14 December 2015

File Number: 2015/658785  
Our Ref: R/2015/26/A

**RE: State Significant Development 7133 – Building W1 Student  
Accommodation, Darling Drive Plot, Sydney International Convention,  
Exhibition and Entertainment Precinct**

SECTIONS

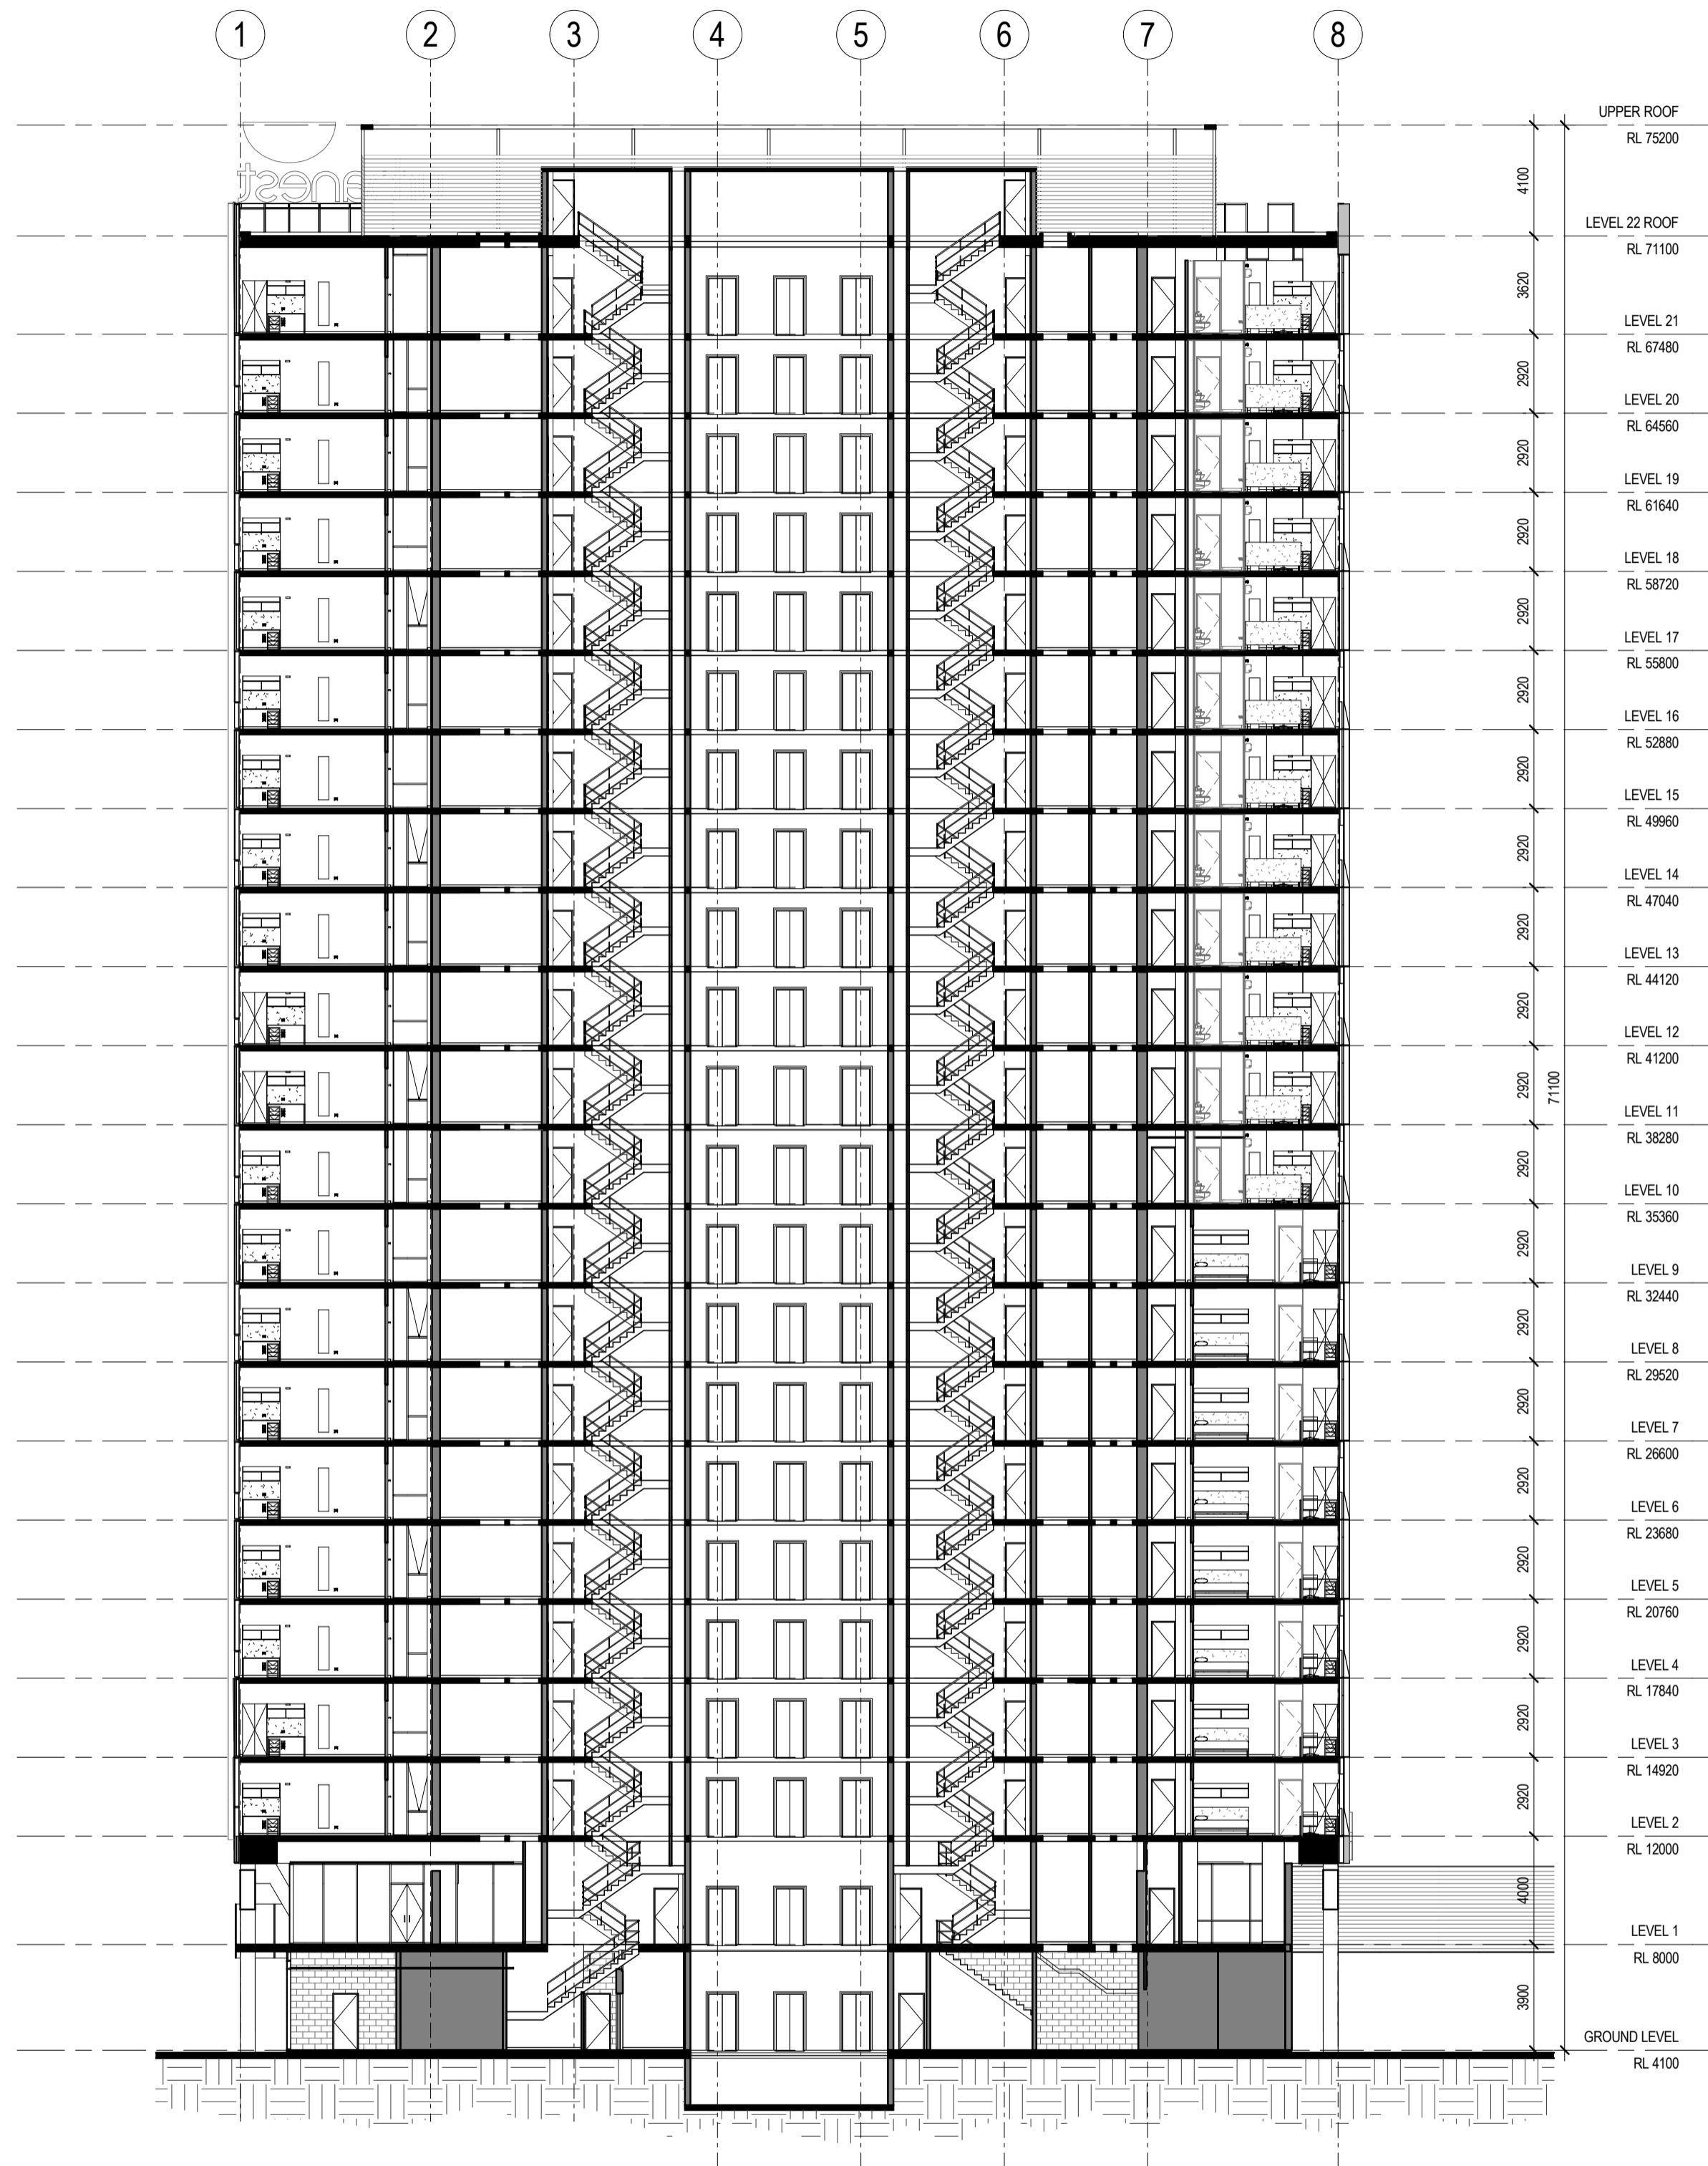
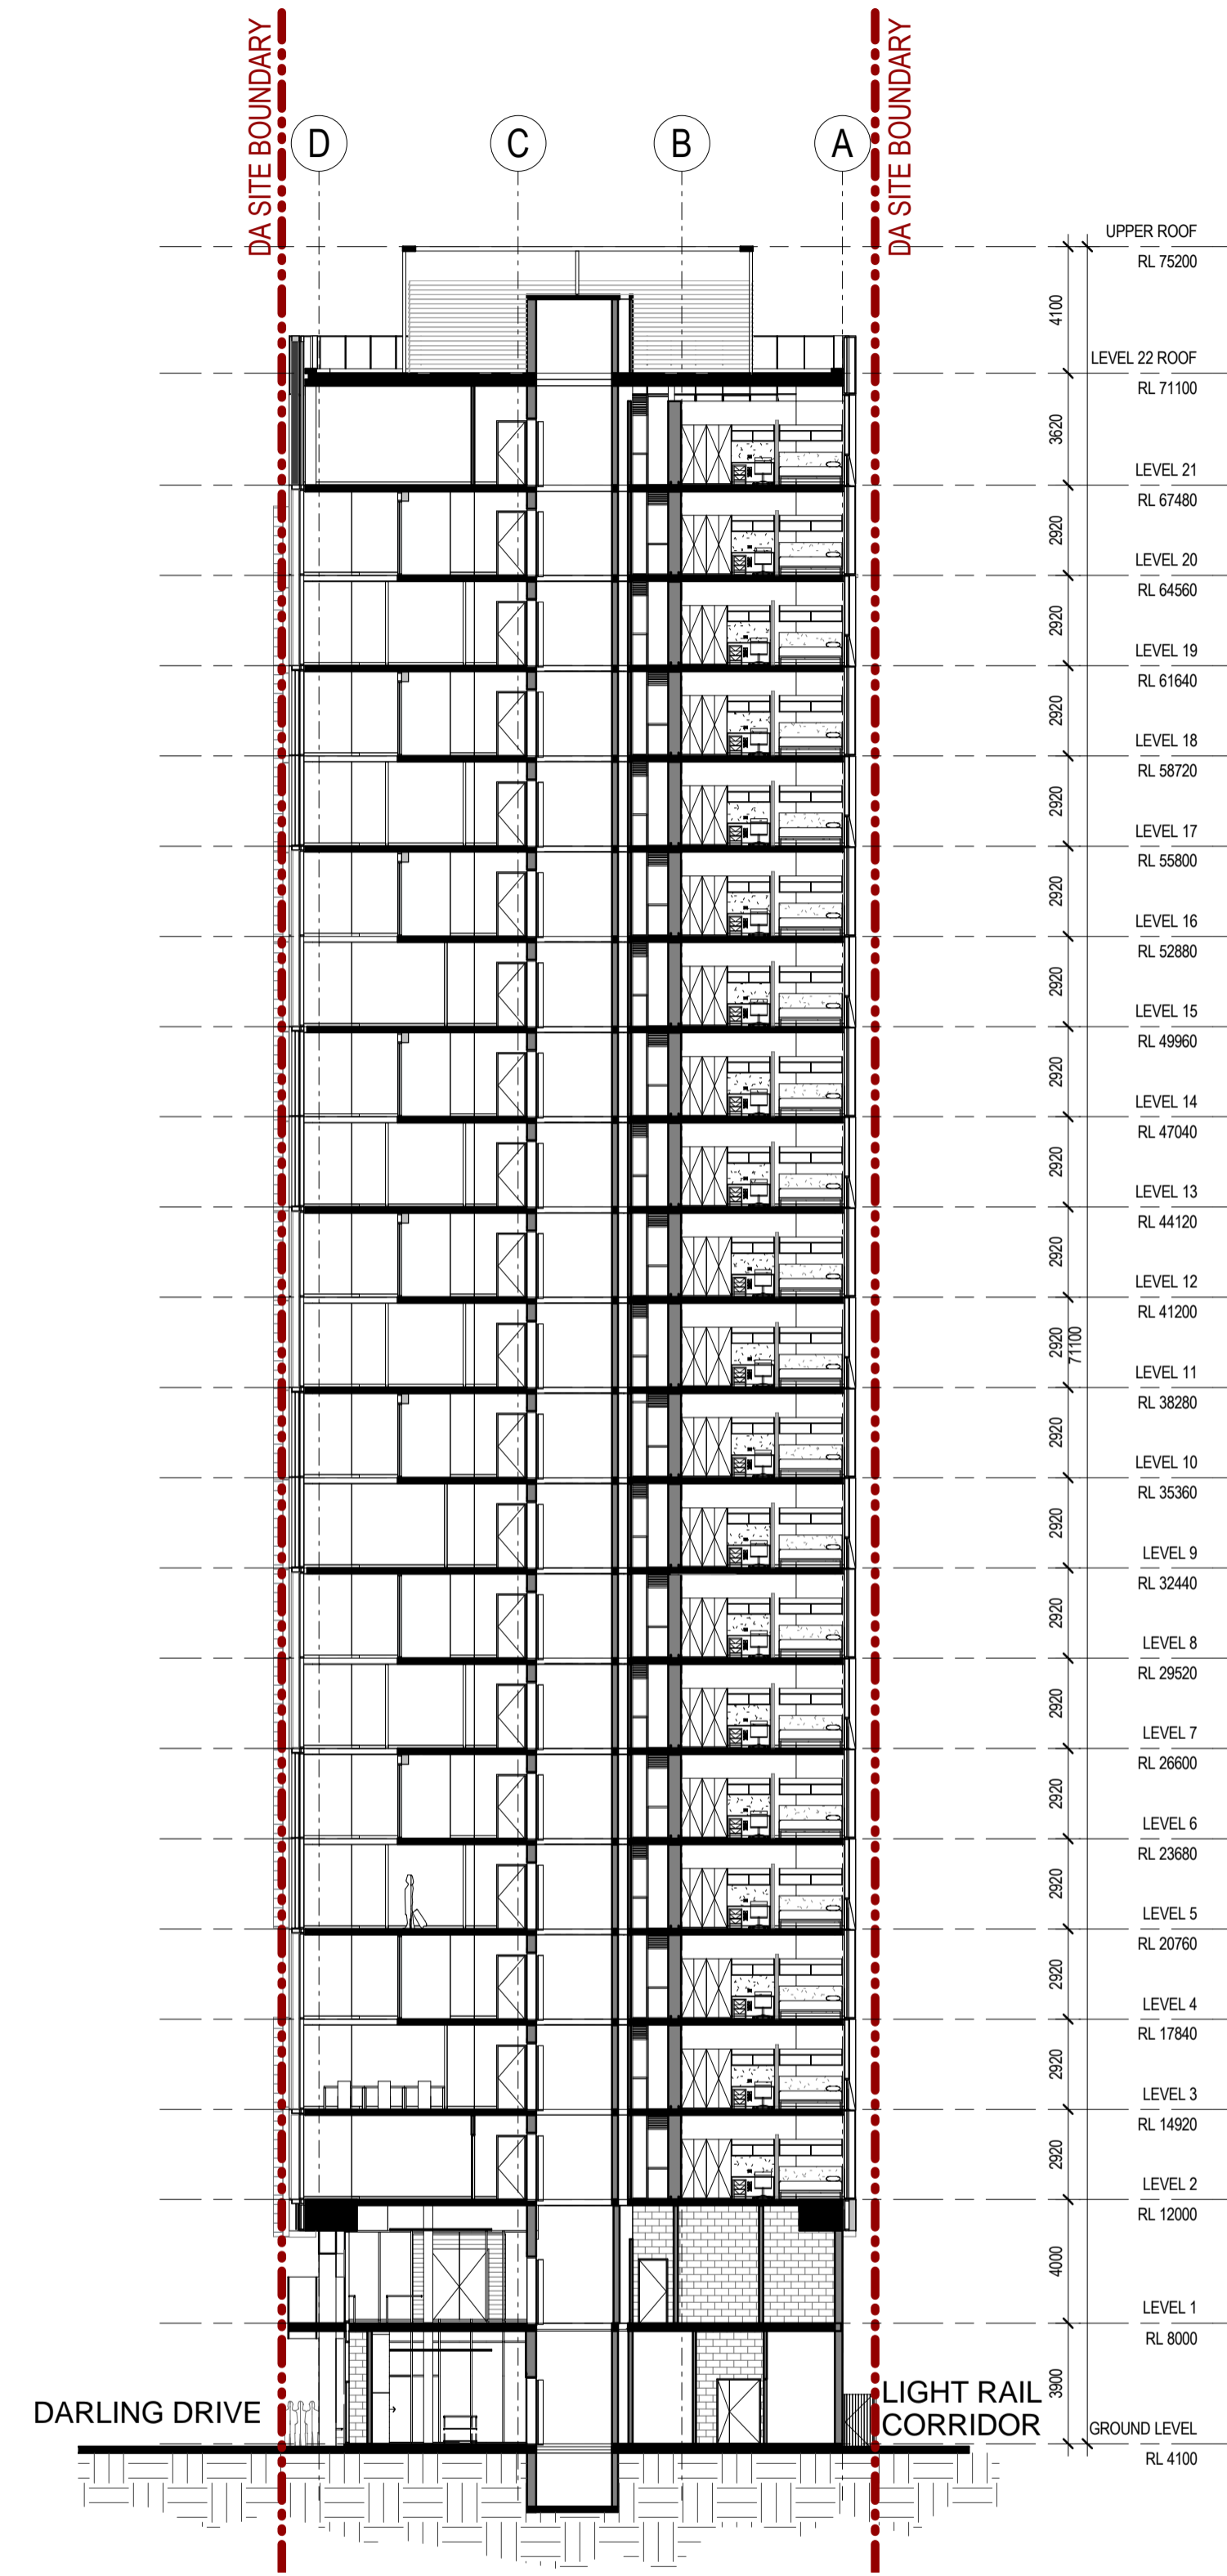
Sections provided show floor-to-floor heights of 2.9m. A floor-to-ceiling height of 2.7m requires a minimum floor to floor height of approximately 3.1m. Given the low ceiling height and lack of natural cross ventilation the amenity of the rooms is considered quite poor, therefore amendments to the ceiling heights should be made.

Type A- Single Bed

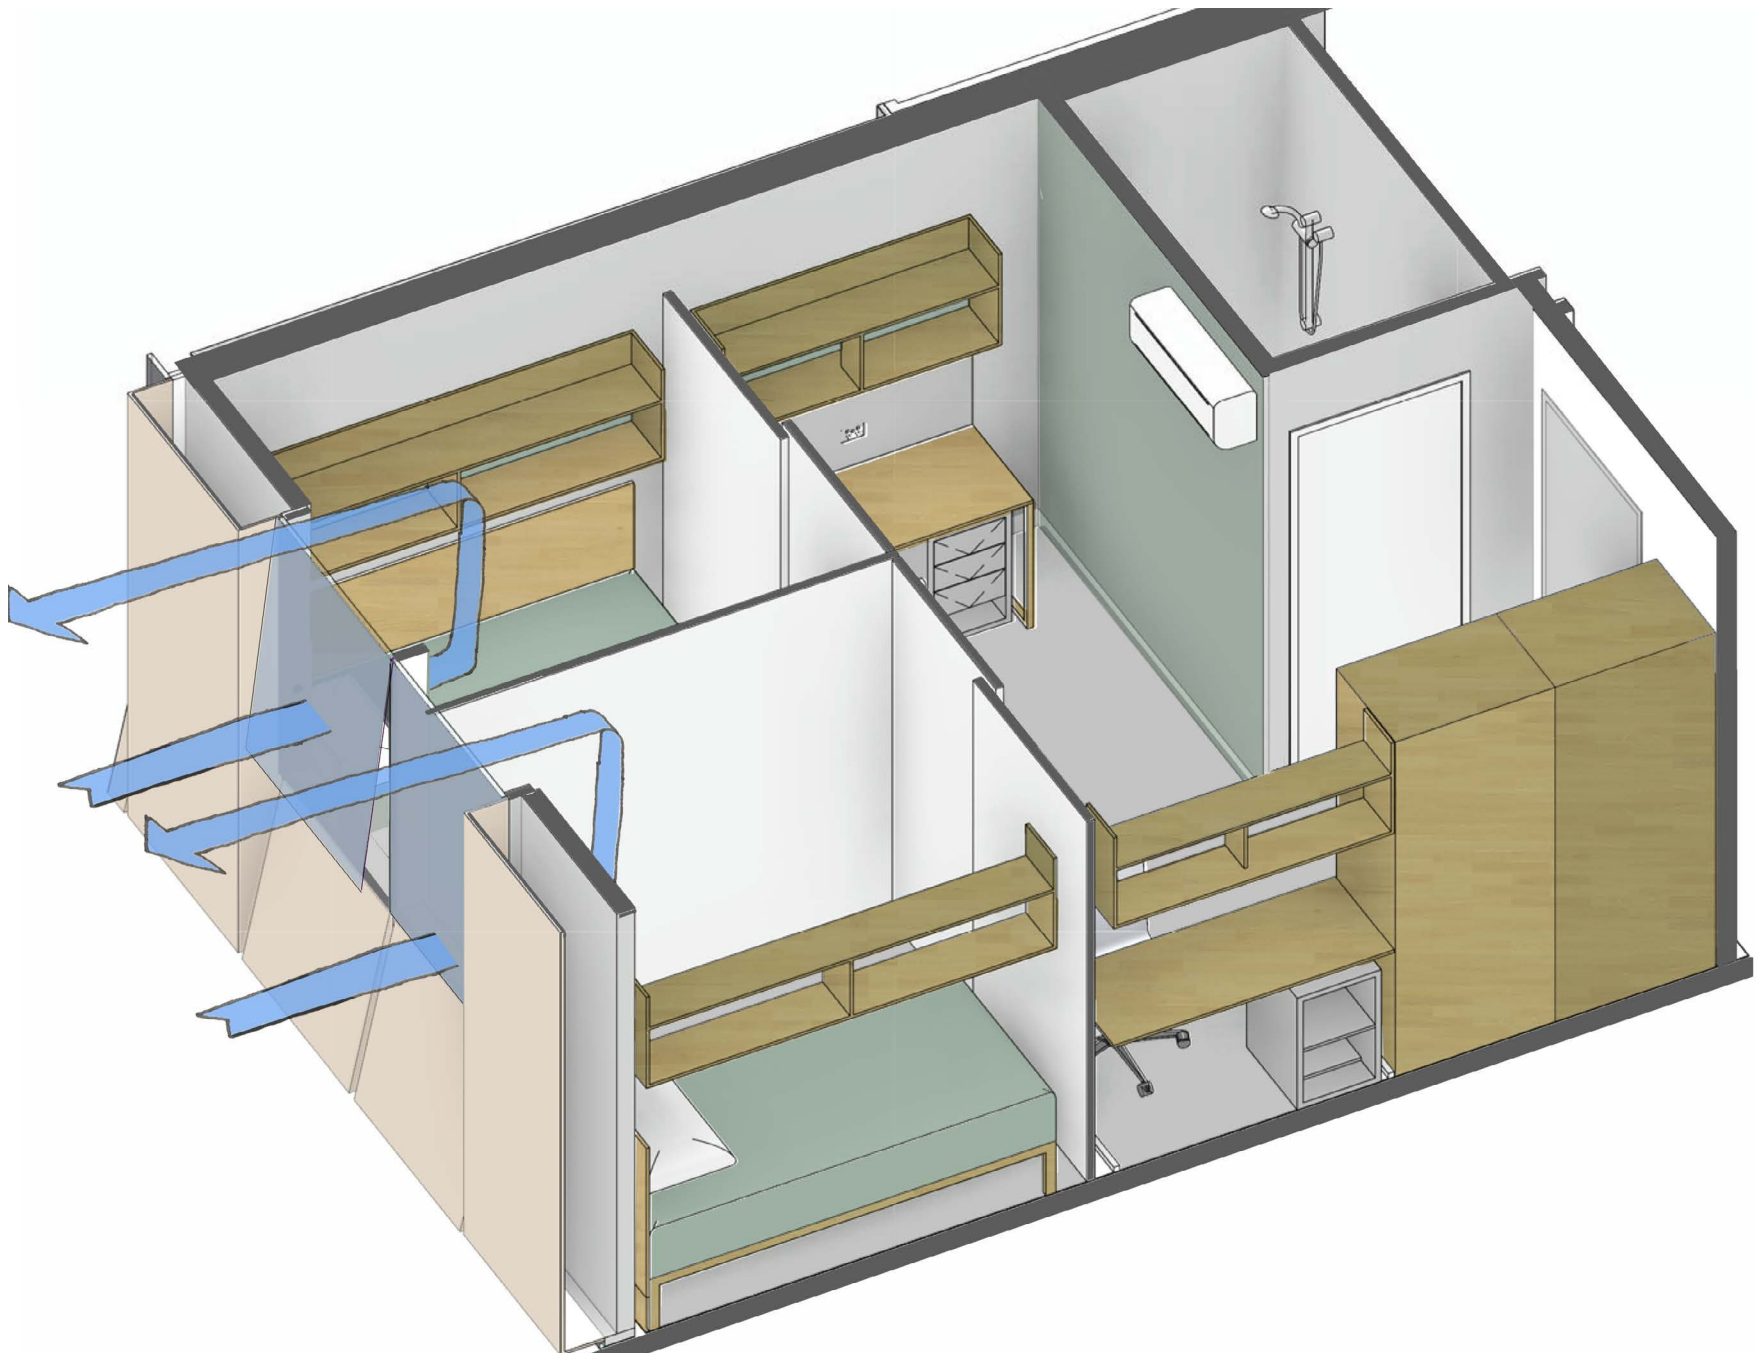
While the twin studios comply with the minimum requirement of 16m<sup>2</sup>, the single rooms do not comply with the minimum requirement of 12m<sup>2</sup>, falling short by 1.1m<sup>2</sup>.

In light of the above, it is recommended that the applicant revise the scheme and increase the size of the single rooms in order to comply. While this will result in the loss of some rooms it is noted that this proposal provides 688 beds and 635 beds have already been approved in Building W2 (SSD 6010). This results in a total number of 1303 beds, which is far in excess of the 1,000 beds envisaged under the Concept Plan Approval (SSD 13\_5878).
